SSD47105958 Uniting Kingscliff Development at 24A Kingscliff Street, Kingscliff NSW 2487
Lodged by: Helen Edwards-Davis, 35 Lorien Way, Kingscliff NSW 2487

I wish to lodge the following objections and comments, regarding the plans for a replacement Aged Care facility, and a Seniors Living estate, proposed by Uniting Kingscliff. My objections concern impacts on my own property, impacts on the immediate surrounding area, and impacts on the township as a whole.

BUILDING A

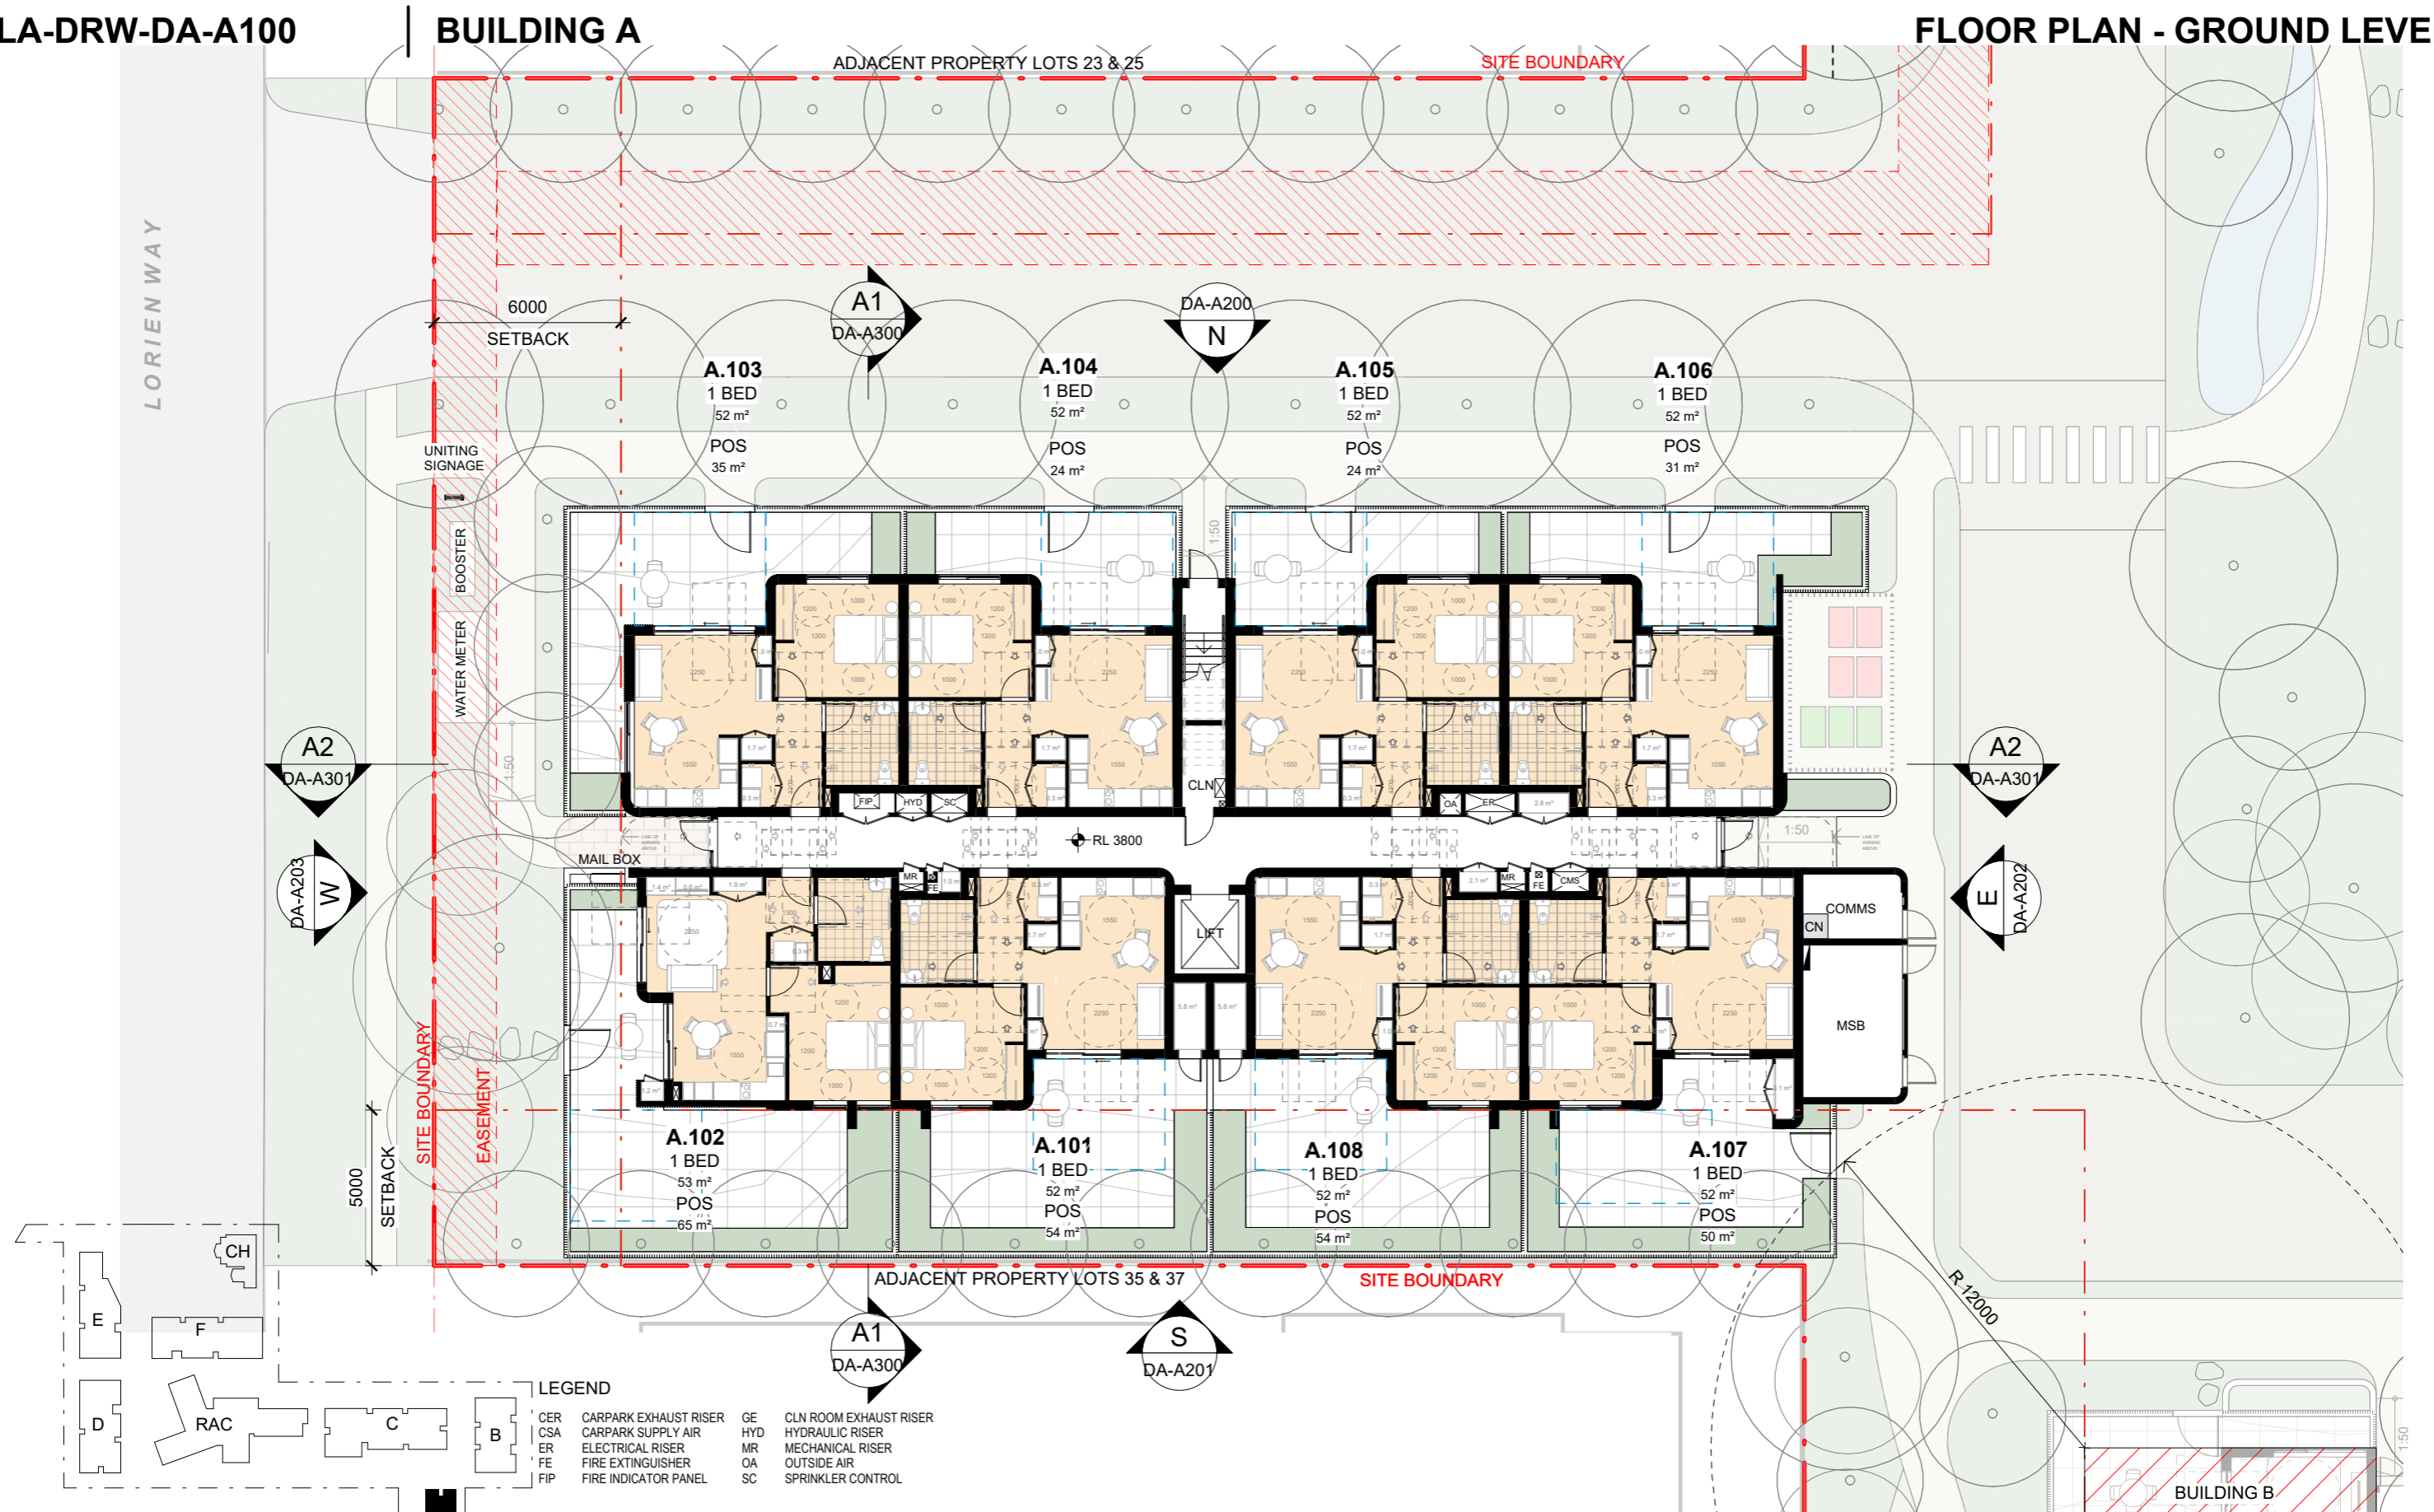
Despite making this undertaking to the State Design Review Panel, **ALL the plan diagrams show that building A is in fact a double loaded corridor, and there WILL be balconies directly overlooking my home, into my living room, kitchen, and dining room. In addition, the building is set back only 5 metres, not the 6 metres required for 2 storey buildings on R2 (low density) zoned land, and the minimum required as noted on page 36 of the Planning Department's Apartment Design Guide.**

So, here I am, looking at the prospect of a two storey building with sixteen ILU's built closer to the boundary than permitted, with balconies looking directly down into my side courtyard, and habitable living spaces. Our neighbours at number 37 have an even worse situation, being overlooked by building A at the side of their house where they have a work-from-home office, and also at the rear, by building B where their courtyard and living areas, as well as their bedroom are located.

I STRONGLY OBJECT to the design of building A, and the way that it impinges on our privacy. I also object to the way the building has been presented to the SDRP, and I take a dim view of the use of misleading artists impressions. Residents did make a proposal to UK to split the building into two separate buildings, with the driveway located in the middle, so that balconies to units overlook their own driveway. No response was given.
